Re: Framing Item
Lot 35 Atherstone
SUMMIT Job No.: 3554.T0493

SUMMIT Engineering, Laboratory & Testing, Inc. (**SUMMIT**) was contacted by Oliver Hudson on behalf of LGI Homes to address a framing issue at the lot referenced above. The structural plans that were used during this evaluation were prepared by **SUMMIT**. All orientations are based on the reader facing the front of the home. Below is a summary of our findings:

Avery LH
 First Floor Framing
 LGI Homes
 7201 Creedmoor Road, Suite 147
 Raleigh, NC 27613

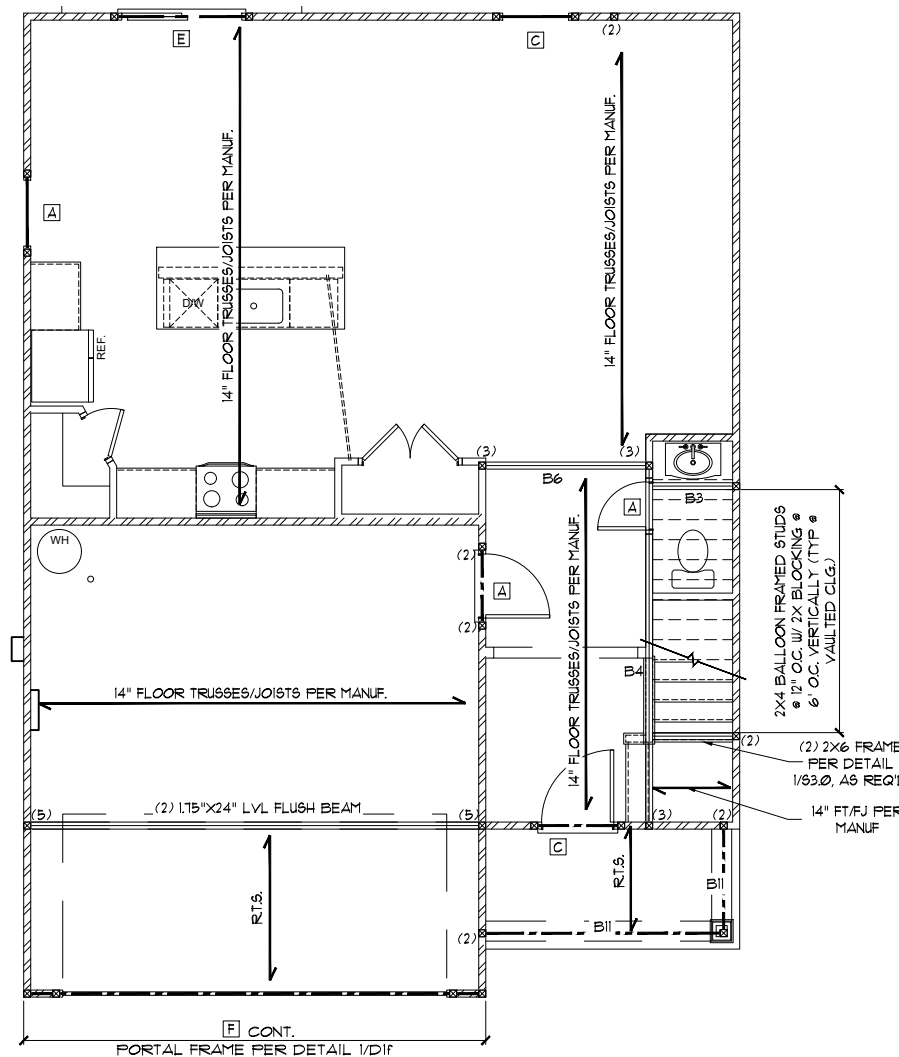
Contractor has requested evaluation of the 2-1.75"x9.25" LVL located over the rear slider door that has been installed in lieu of a 2-2x12 header as shown on the plans.

Based on our review, the 2-1.75"x9.25" LVL header is an adequate substitute to the 2-2x12 header. No action is required.
